From: wilpshire parish council <wilpshireparishcouncil@gmail.com>
Sent: 09 October 2020 21:49
To: Planning <planning@ribblevalley.gov.uk>; wilpshire parish council <wilpshireparishcouncil@gmail.com>
Subject: 3/2020/0568 Carr Hall

Application 3/2020/0568 Carr Hall

The application exists to create a Business Park in the Green Belt at Carr Hall. Wilpshire Parish Council strongly objects on the following grounds:

PROPOSED ELEVATION TO WOOD

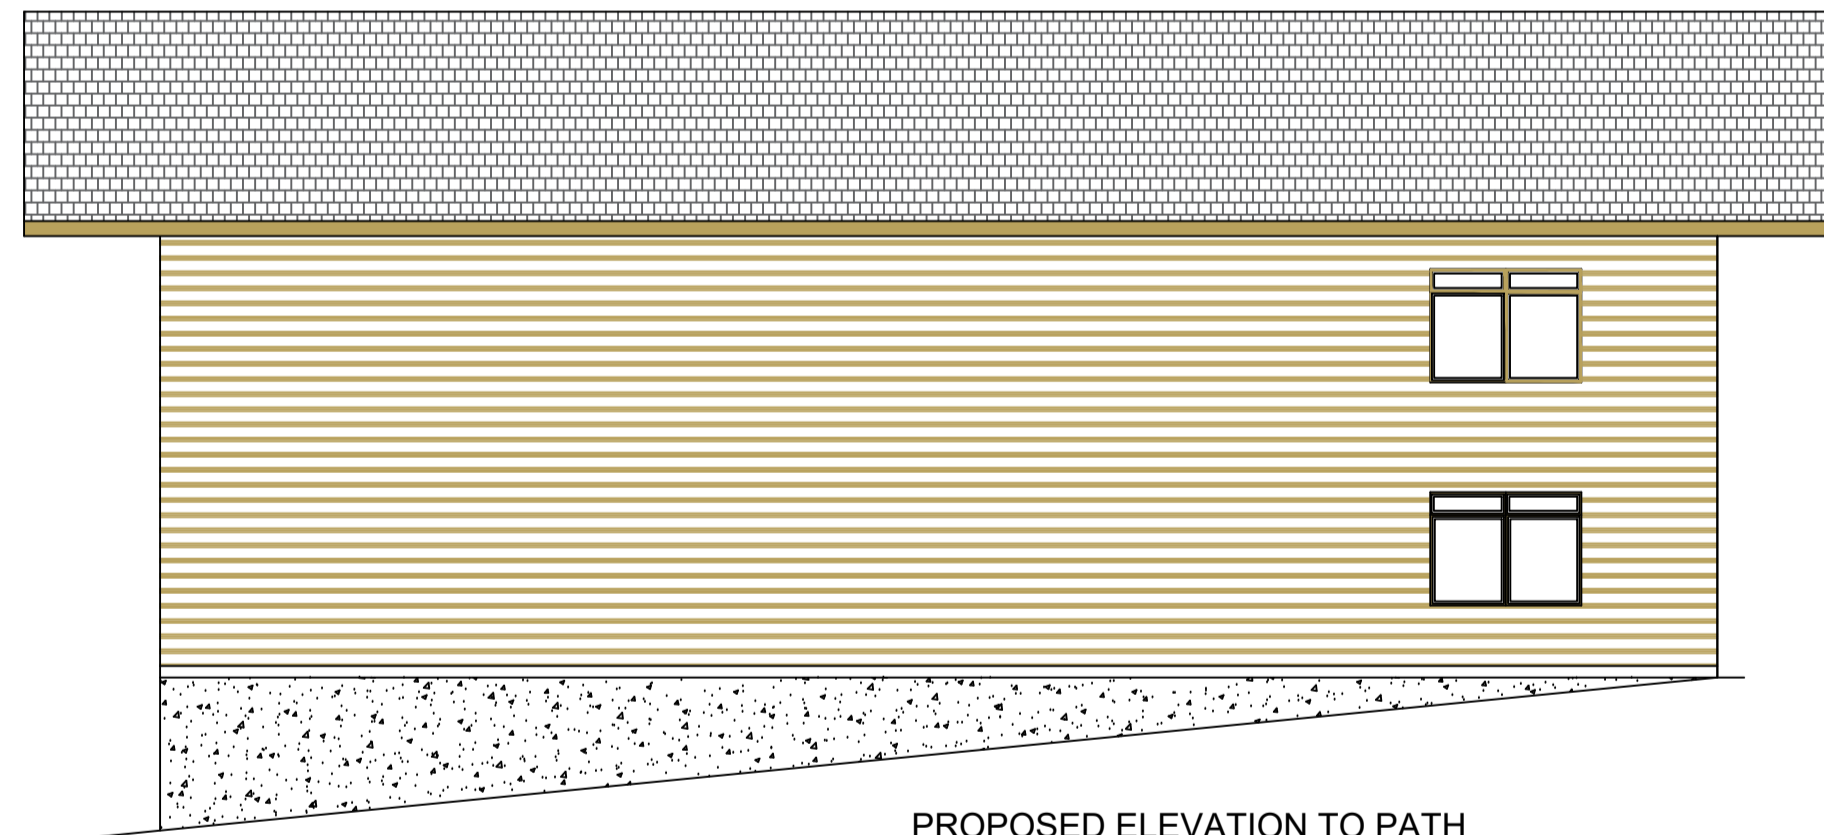
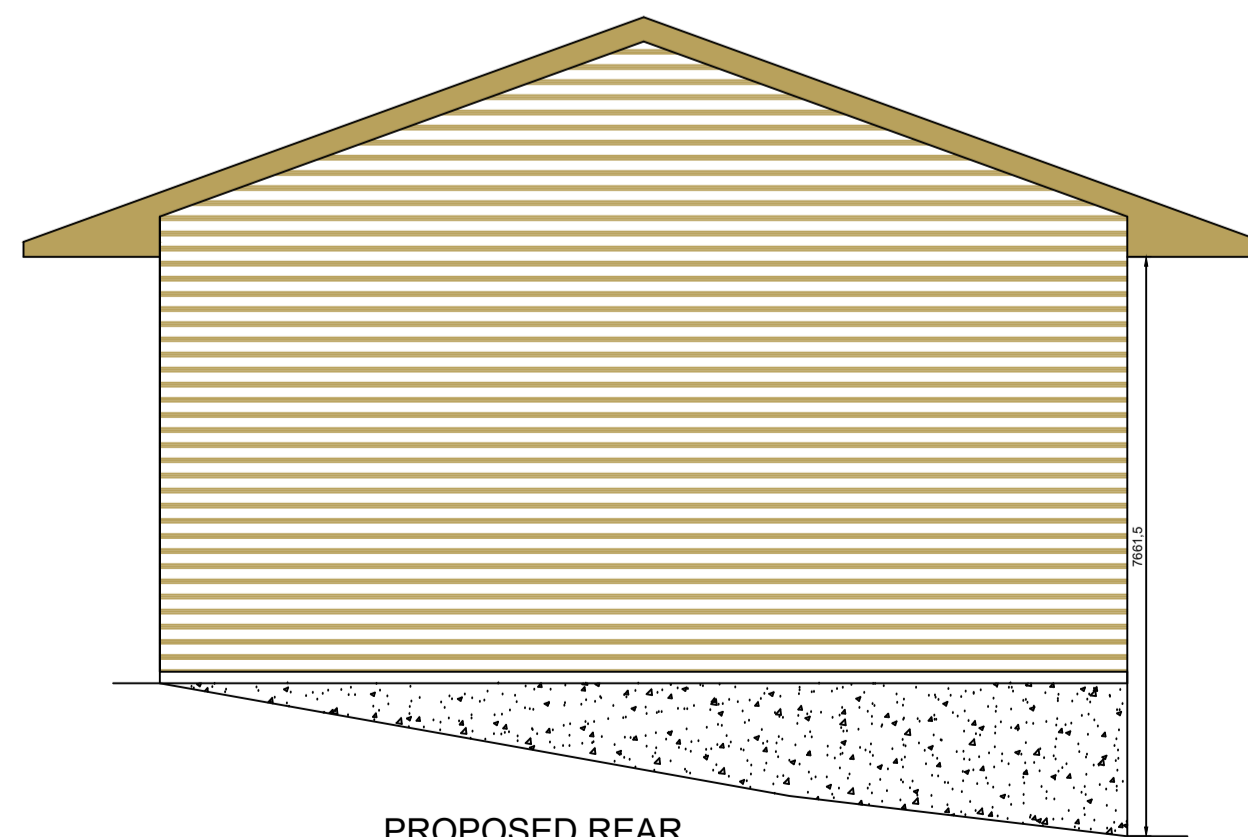
- The two proposed large and tall buildings (the store/workshop is 7.6m high just to the eaves) will be readily visible from the A666 and nearby footpaths; also they will be dominant to users of the footpath through the site.

Glamping Pod

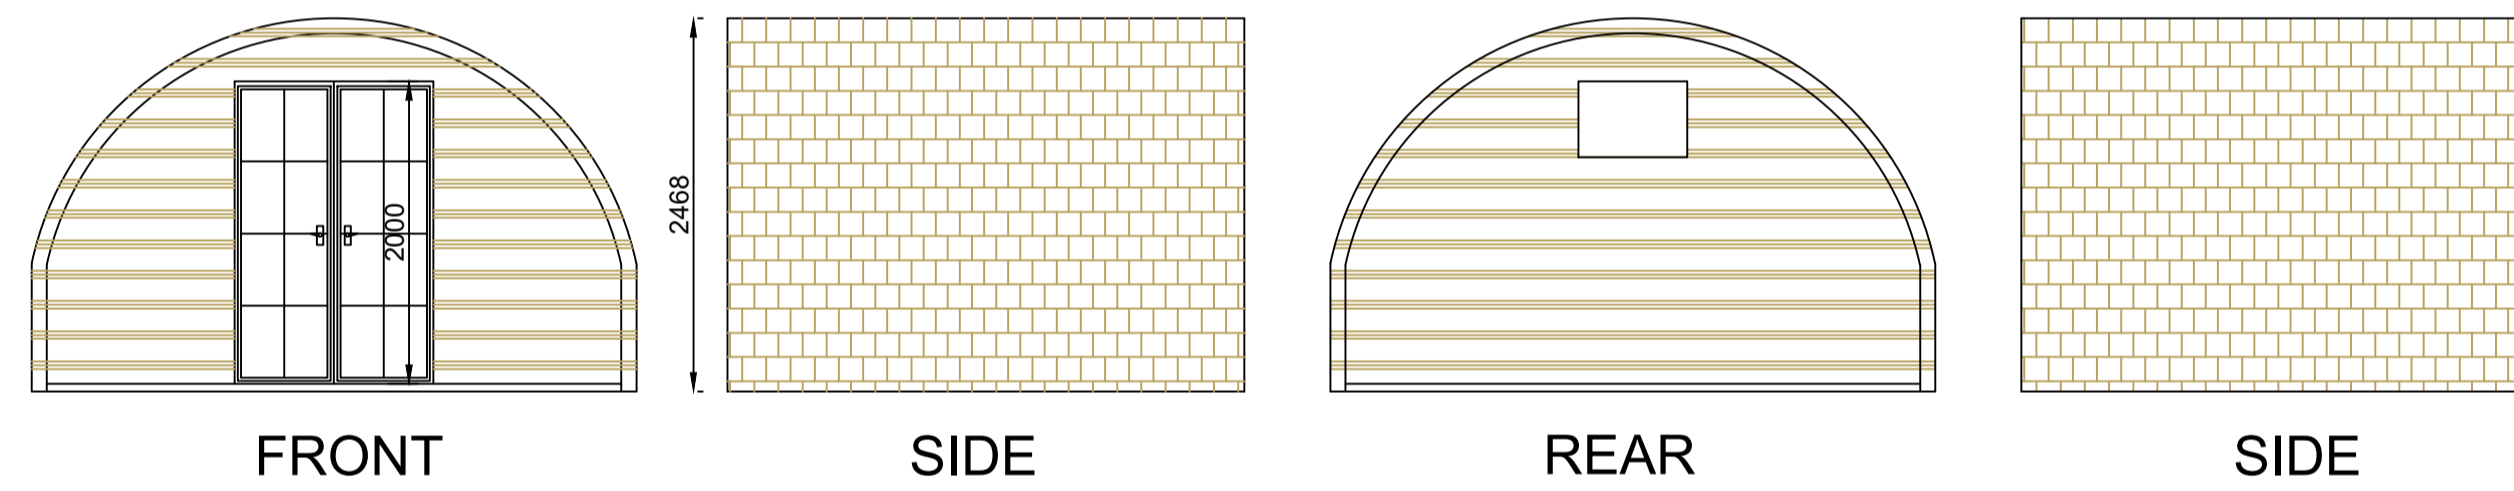
- The proposed Glamping Pods and access track are in a prominent position on the steeply sloping site.
- The 8ft high security fencing to the play area would further reduce the openness and particularly for users of the footpath through the site.

4. Residential amenity: Even with electric vehicles there would be significant and continuous noise from vehicles using the off road tracks. The Glamping Pods and associated Fire Pit , especially as they are in an elevated position, will potentially be a source of noise which will carry far and wide.

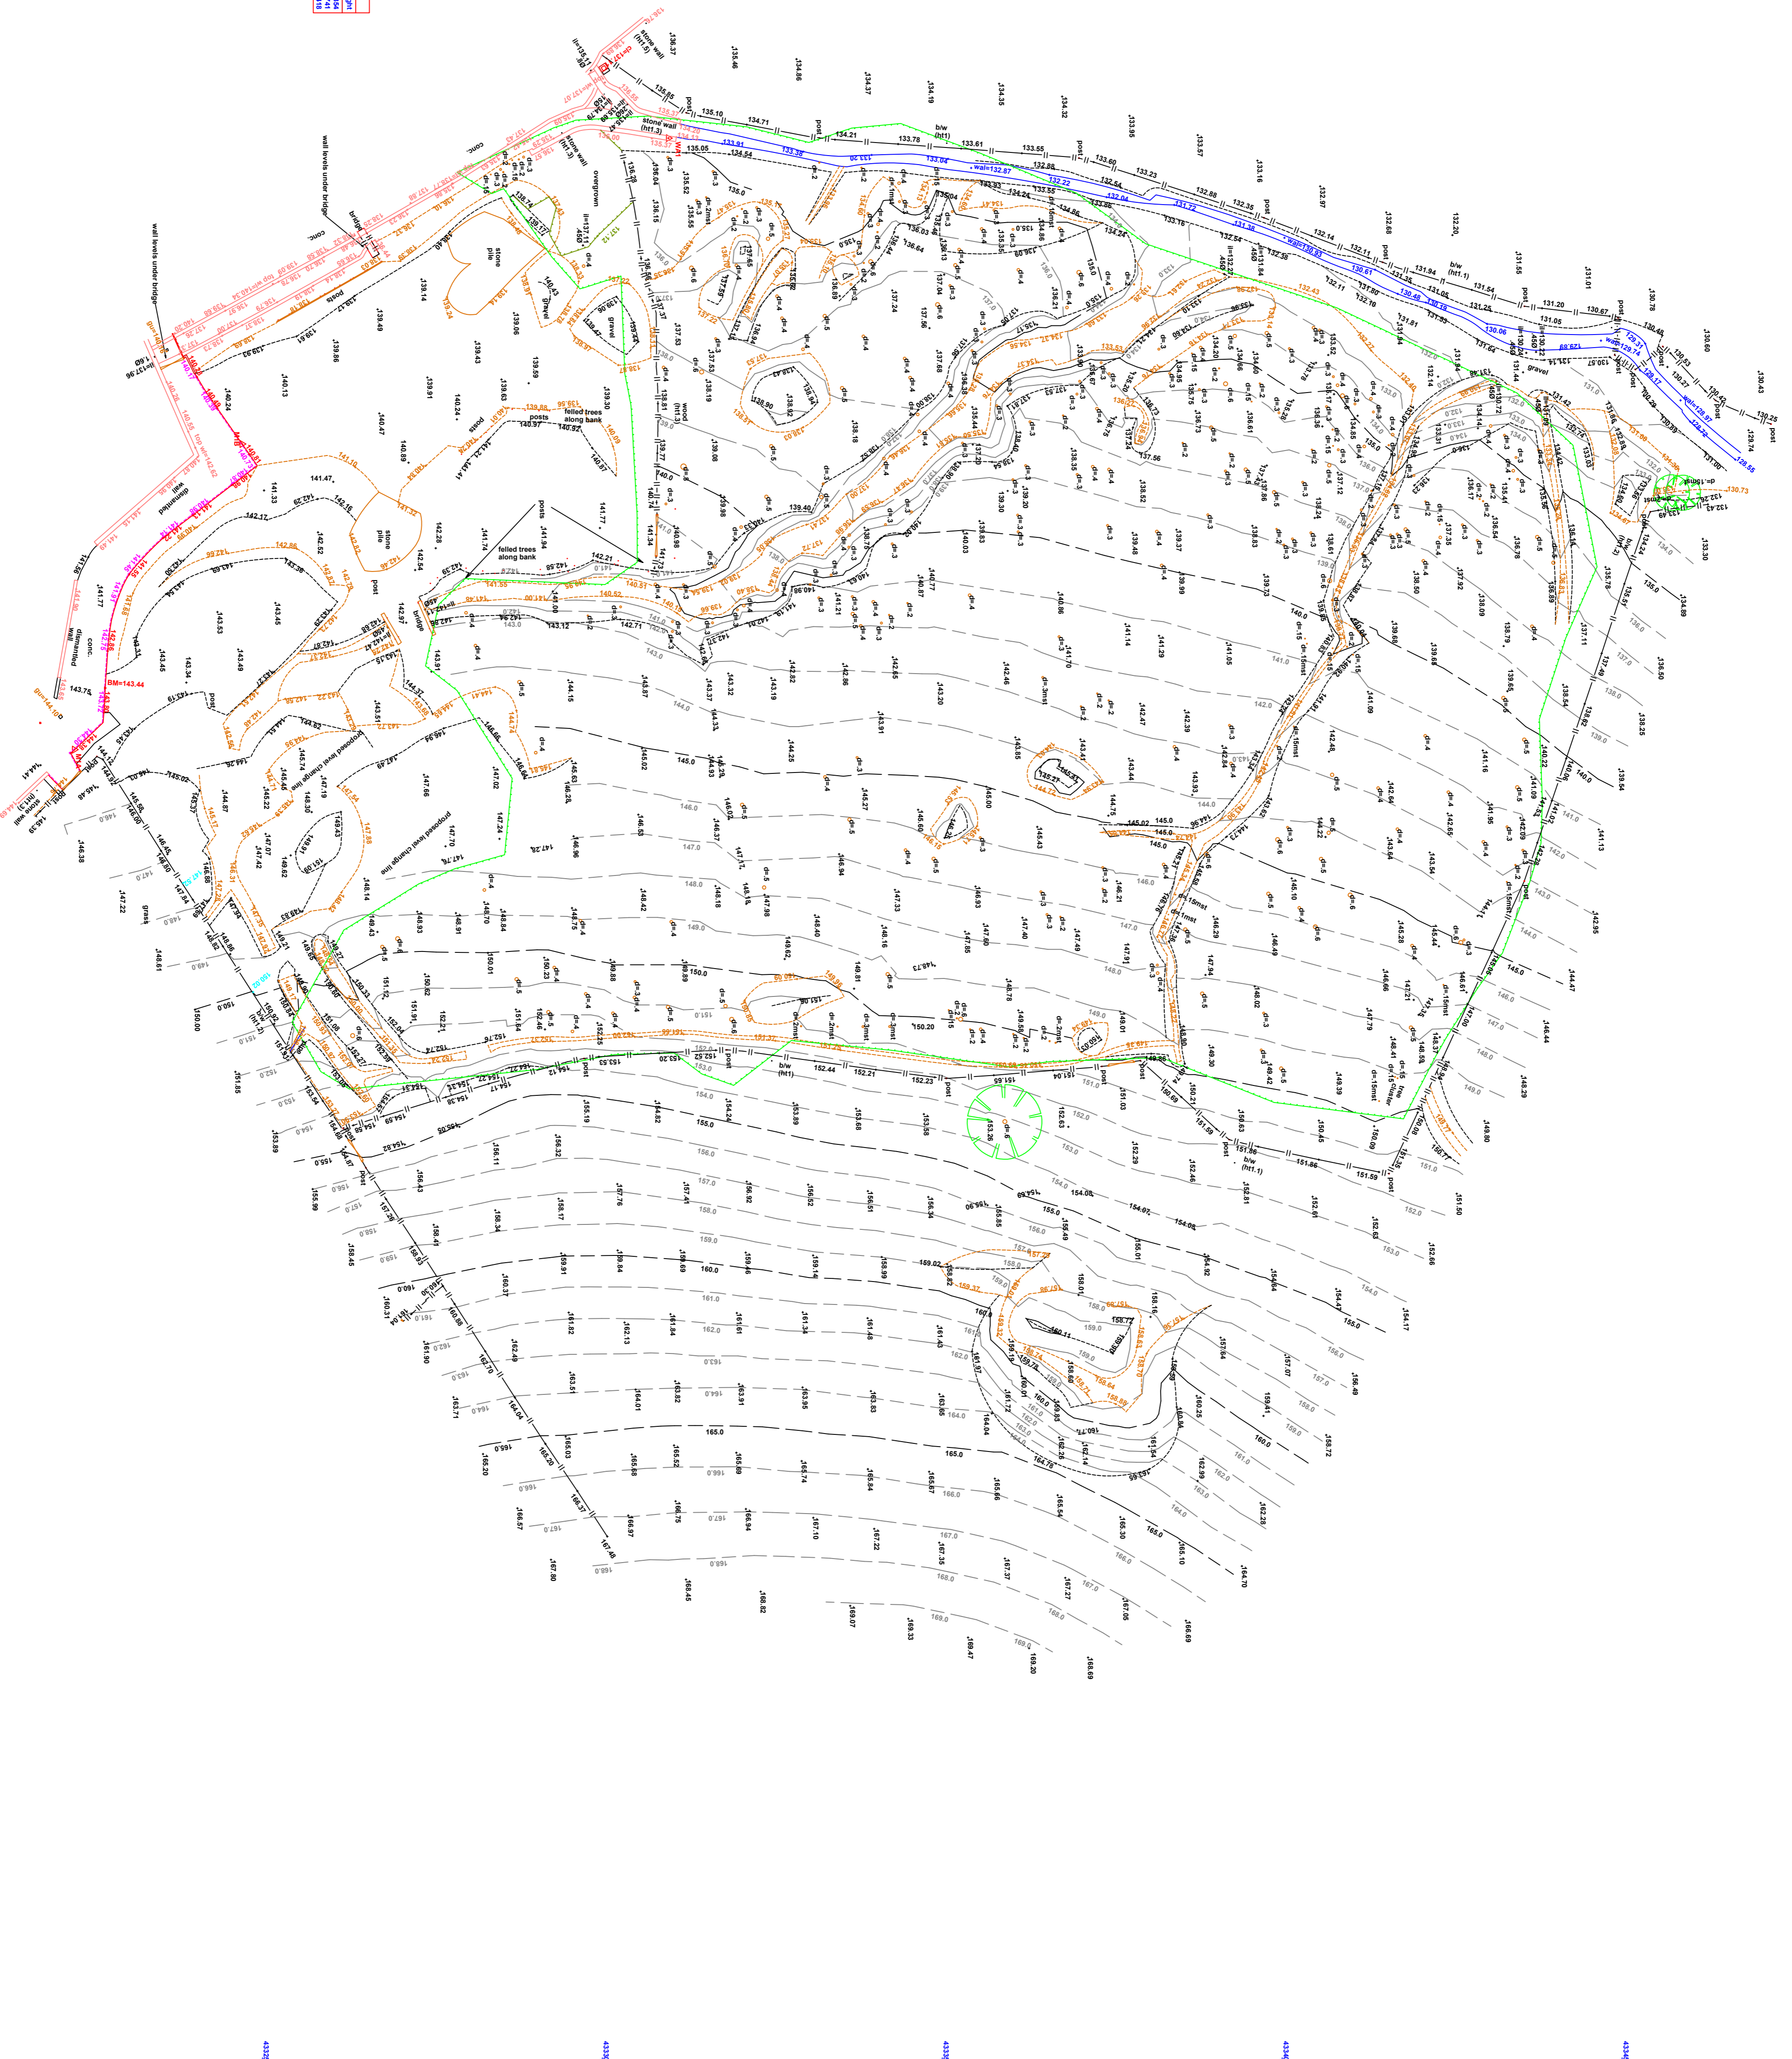
The proposed development is on a steeply sloping site on a prominent escarpment readily visible from the A666. The applicant's own topographical map shows the difference between lowest and highest points on the site is over 100 ft.
